# **M25 junction 10/A3 Wisley interchange**

**TR010030**

## **10.1 Report on Proposed Scheme Changes**

February 2020

Figure 3.1 – Widened “Green Element” of Cockcrow Bridge

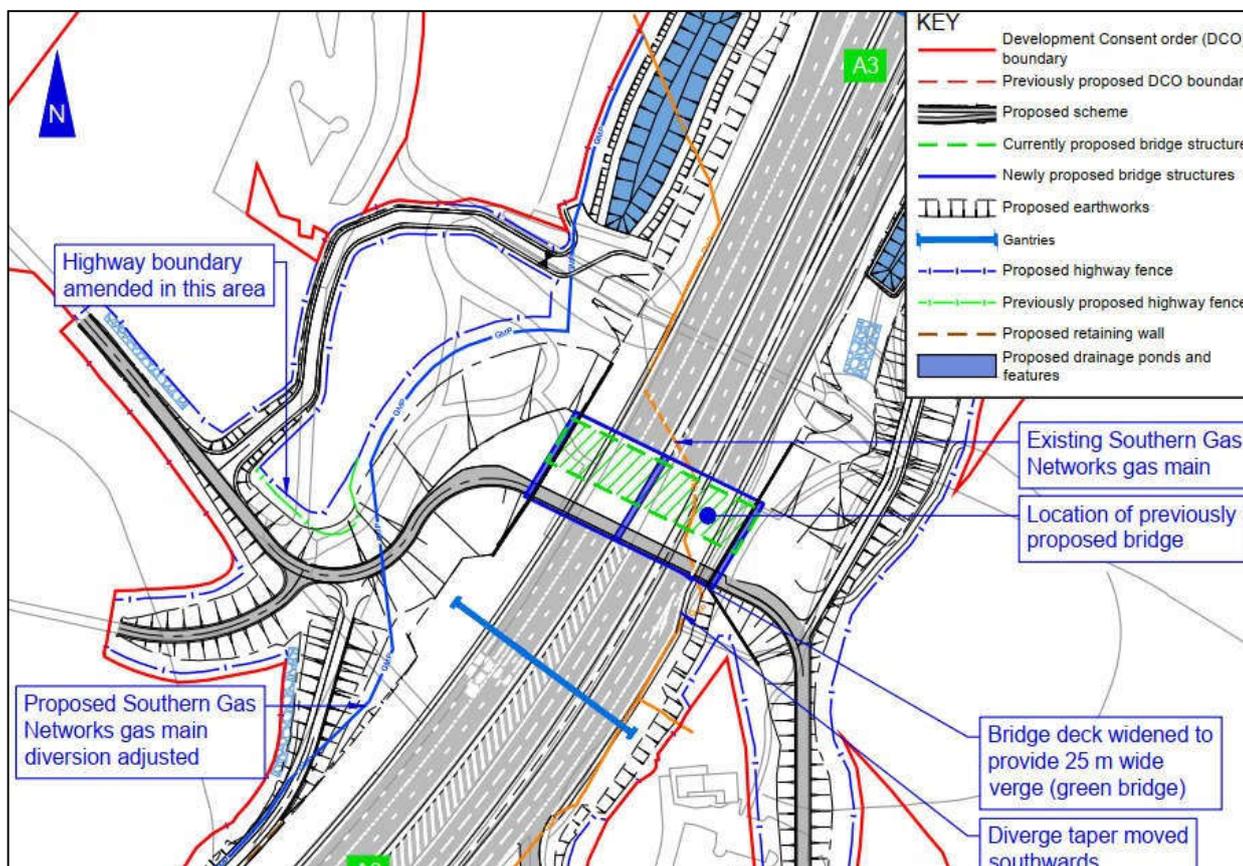
3.1.1 Following stakeholder engagement, Highways England proposes to increase the width of the green verge at the new Cockcrow Bridge from the 10 metres provided for as part of Work No. 35(b) in Schedule 1 of the dDCO to a 25 metre width. This change is supported by relevant stakeholders including Surrey County Council and Surrey Wildlife Trust.

3.2.2 It will also increase the footprint of the green bridge within the existing Scheme boundary on account of the wider approach ramps which will be necessary given the expanded width of the bridge.

3.2.3 The widened approach embankments will require the placement of an additional 5000 m<sup>3</sup> of material.

Figure 4.1 – Proposed Toad Underpasses on Old Lane

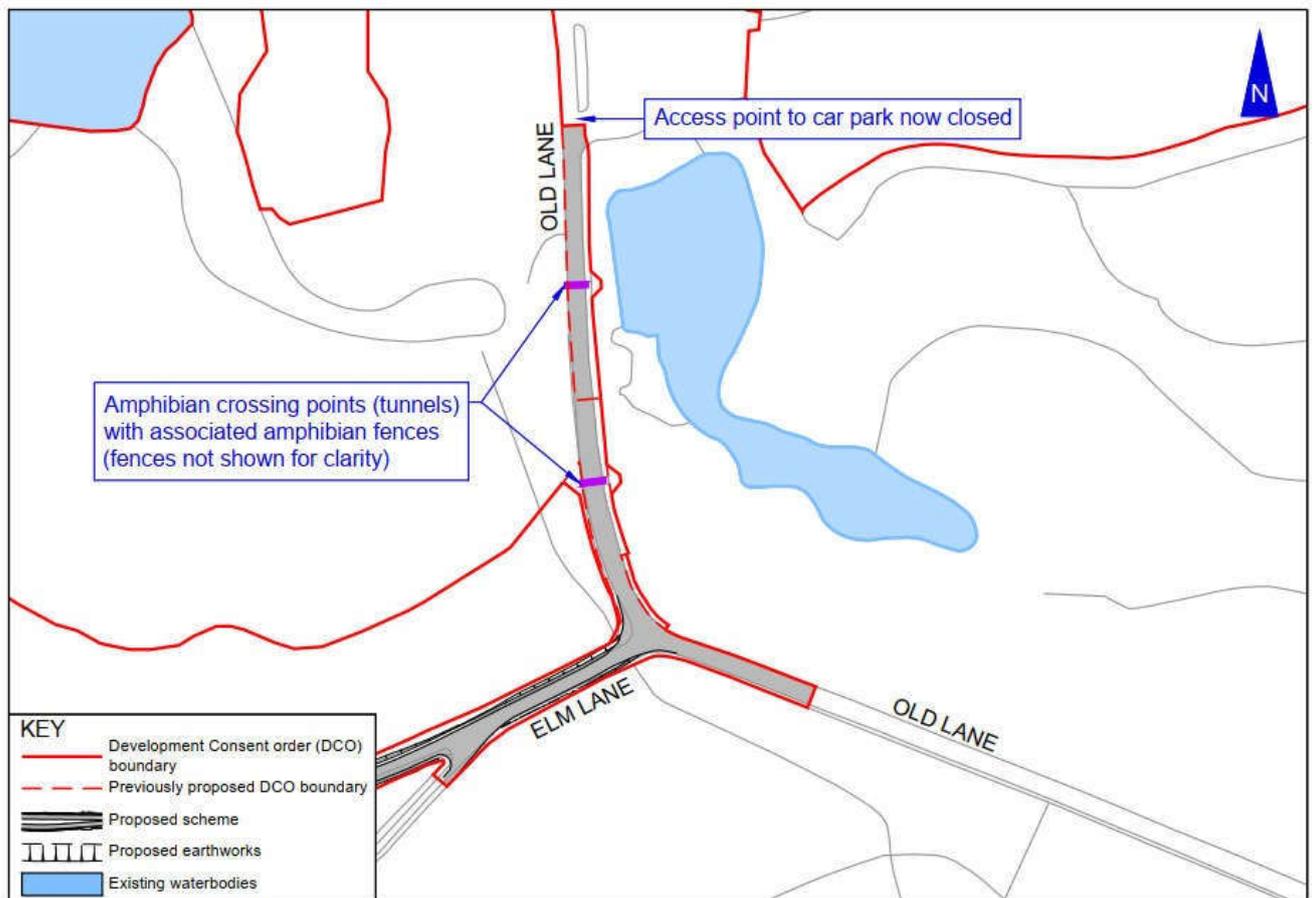
- 4.1.1 In response to stakeholder representations, Highways England has identified mitigation for an increase in toad mortality which is likely to occur at Old Lane and Elm Lane as a result of the Scheme prior to mitigation.
- 4.1.2 Accordingly, Highways England proposes to develop mitigation measures to include two toad underpasses at a section of Old Lane together with reptilian fencing to direct the toads to the underpass crossing points. Additional signage will also be provided along Elm Lane.

- 4.1.3 The proximity and relative level of the water body to the east of Elm Lane means that the form of the underpass is likely to be shallow and most likely to be contained within the structure of the existing carriageway.

- 4.2.7 The amendment to the Scheme will consist of two toad underpasses at a section of Old Lane together with wildlife fencing to direct the toads to the underpass crossing points. This will allow safe dispersal to and from the two breeding ponds on either side of Old Lane for a section of the road approximately 150 m in length. In addition, signage will be provided at Elm Lane to increase vehicle users' awareness of the possibility of toads on the lane.

- 4.2.11 The proposals include two 150 m lengths of 300 mm high wildlife barrier either side of Old Lane which would have negligible effect on the landscape or visual impact of the scheme.

Figure 5.1 – Revised Layout of A245 Eastbound Carriageway

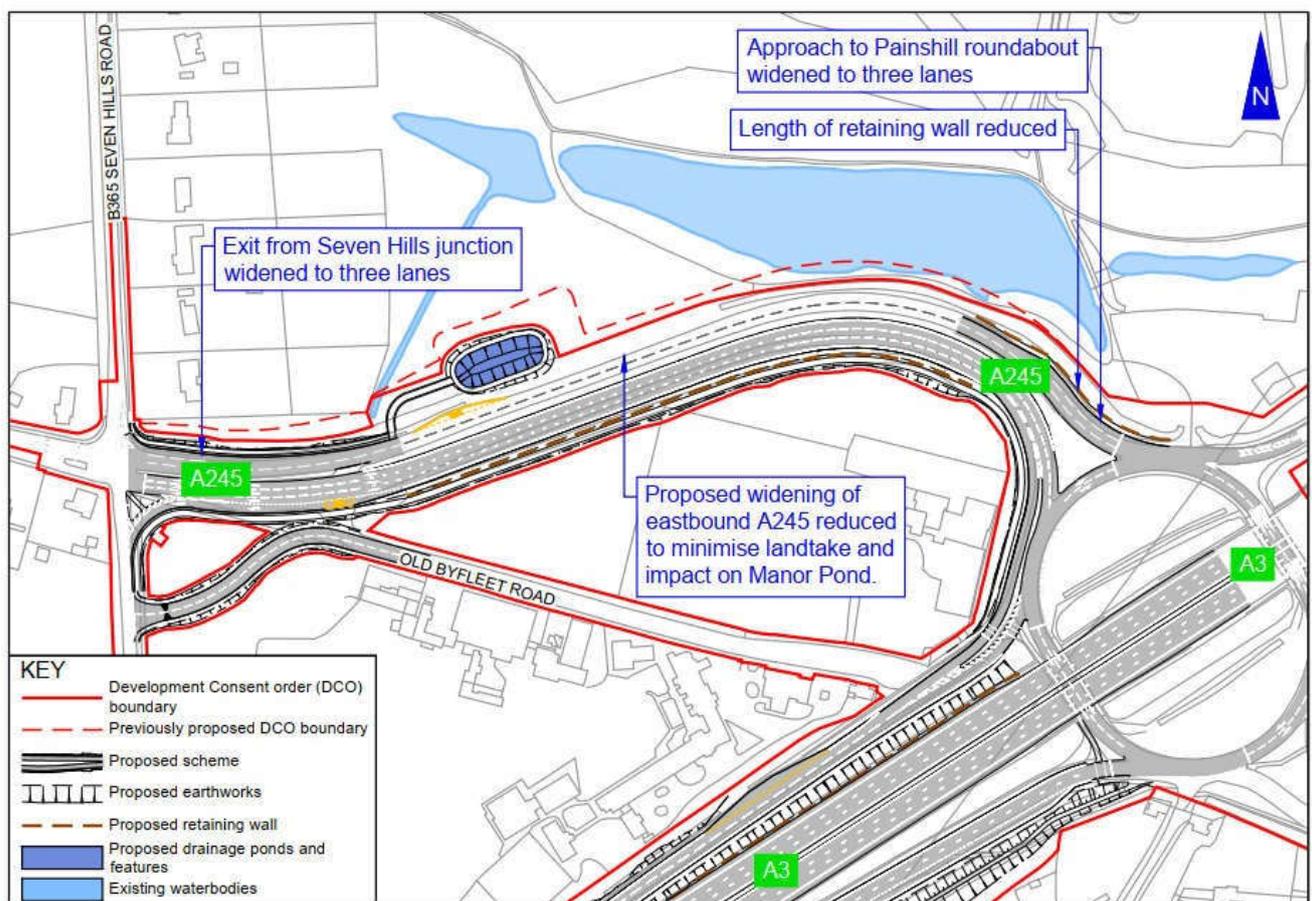
- 5.1.2 Highways England has undertaken further traffic modelling of the traffic flows at this junction in consequence of the incorporation of a banned right-turn and in the light of that modelling it is no longer necessary to widen the entirety of this section of the A245 to three lanes as it passes Manor Pond and approaches the A245/A3 Painshill interchange.

- 5.1.4 Accordingly, it is no longer necessary to construct Work No. 47(c), comprising the construction of a retaining wall at Manor Pond, which it is proposed will be removed from the dDCO in consequence of this change.

- 5.2.1 The principal benefit of this change is that it would avoid the current impact on Manor Pond. The change will also reduce the extent of land needed from Burhill Developments Limited and CALP Angling Club.

Figure 7.1 – Amendments to Order limits to accommodate new Gas Main Crossing

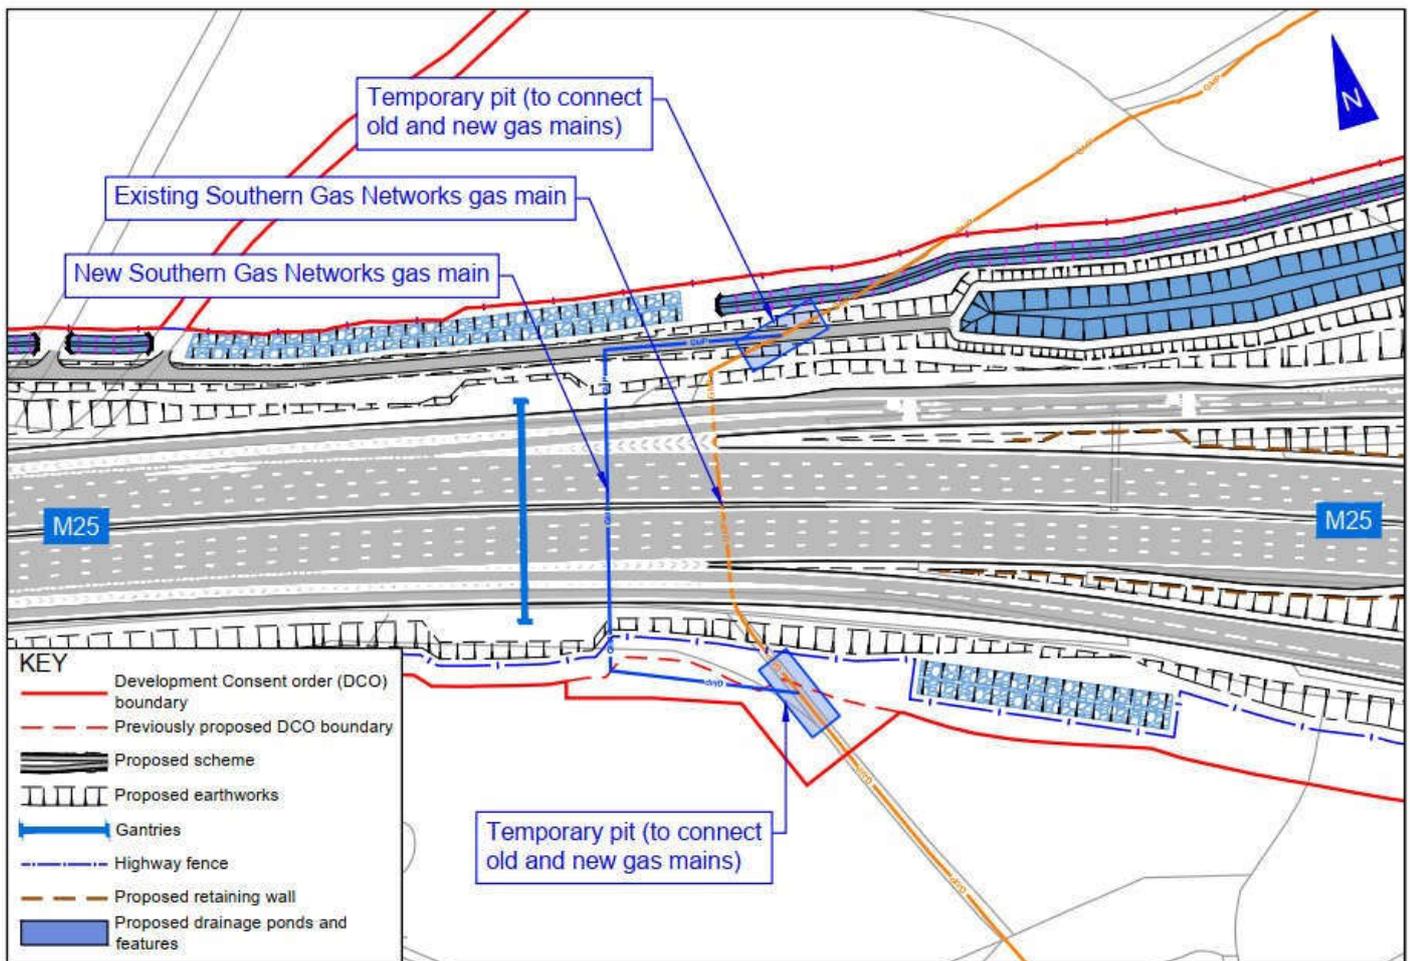
- **Change 5** Adjustments to the Order limits in the dDCO to accommodate a revised diversion of a gas main.
  - **Change 6** Amendment to the speed limit at Elm Lane (and including Byway 525 – Byway Open to All Traffic).

Inset: Sheet 4A. Scale 1:2,000

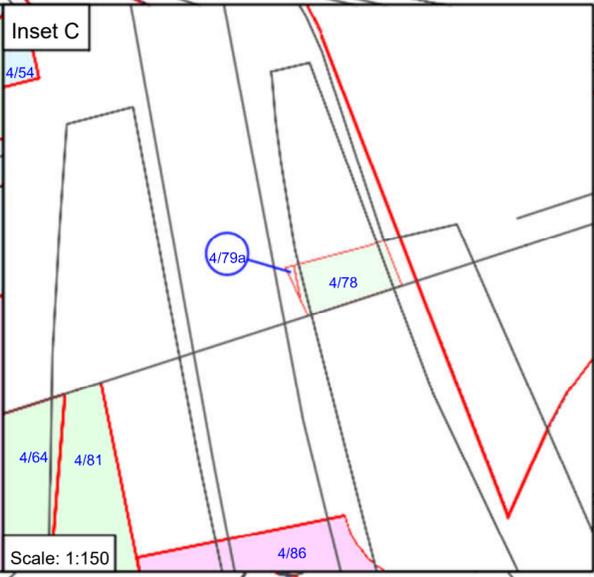
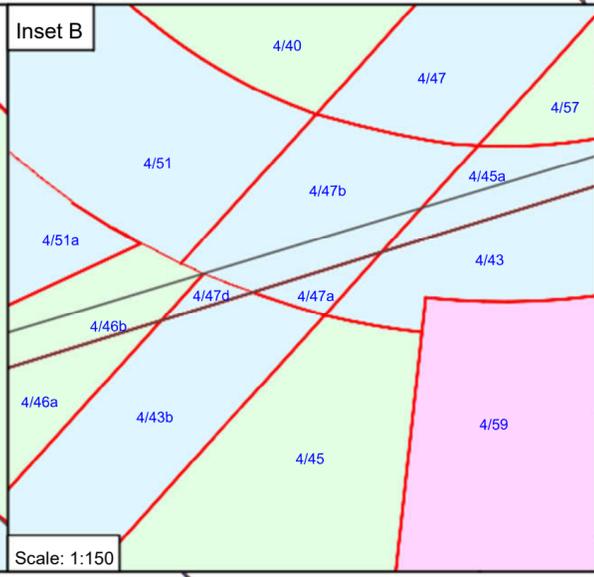
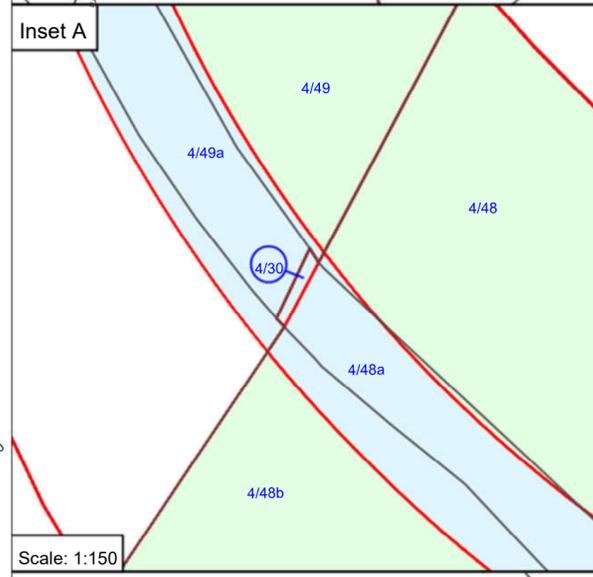
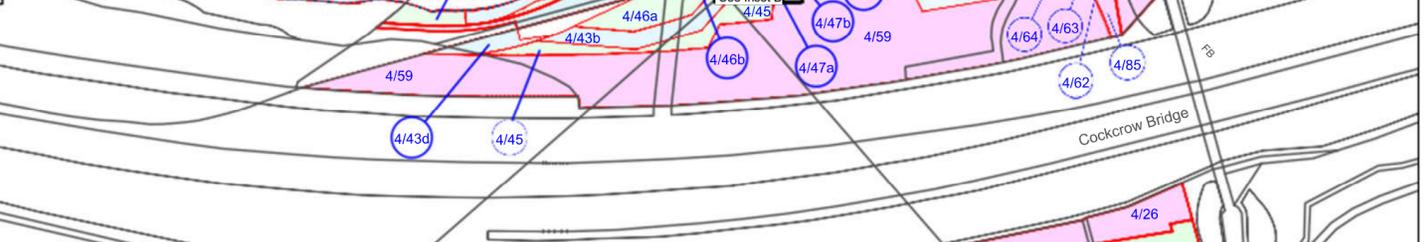
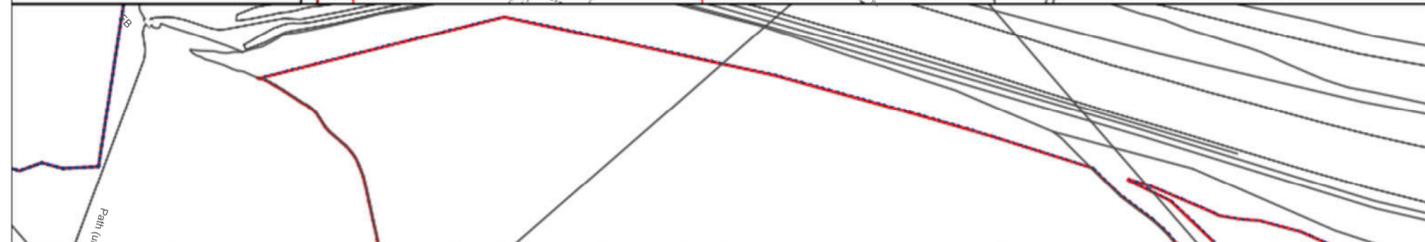
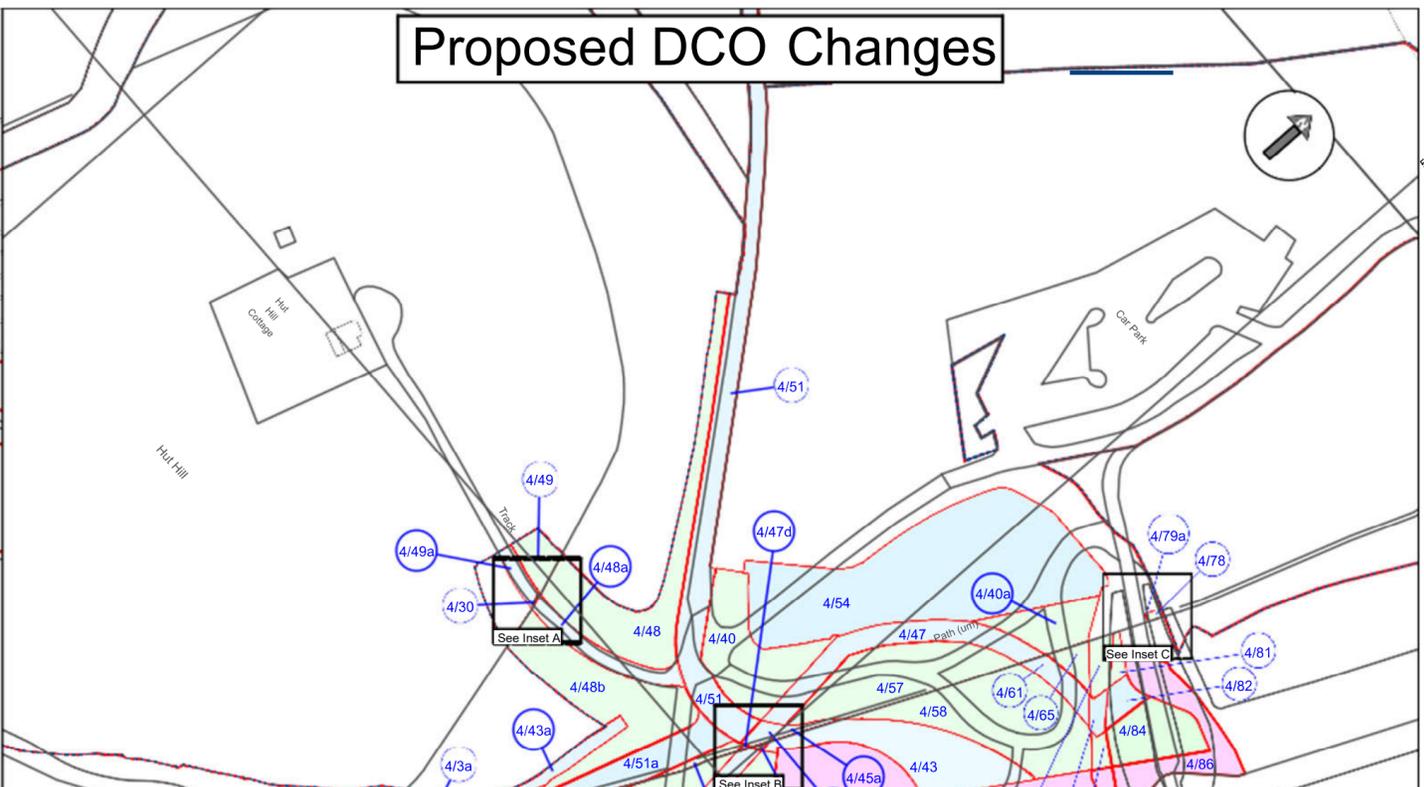
3.2.1 This amendment will not involve any changes to the red line boundary however it will change the category of land acquisition and size of a number of land plots within the application. The changes to the land-take required for this change are shown on the Land Plans and addendum to the Book of Reference submitted in support of the Proposed Changes. As noted in Section 1 above, this change engages the 2010 Regulations.
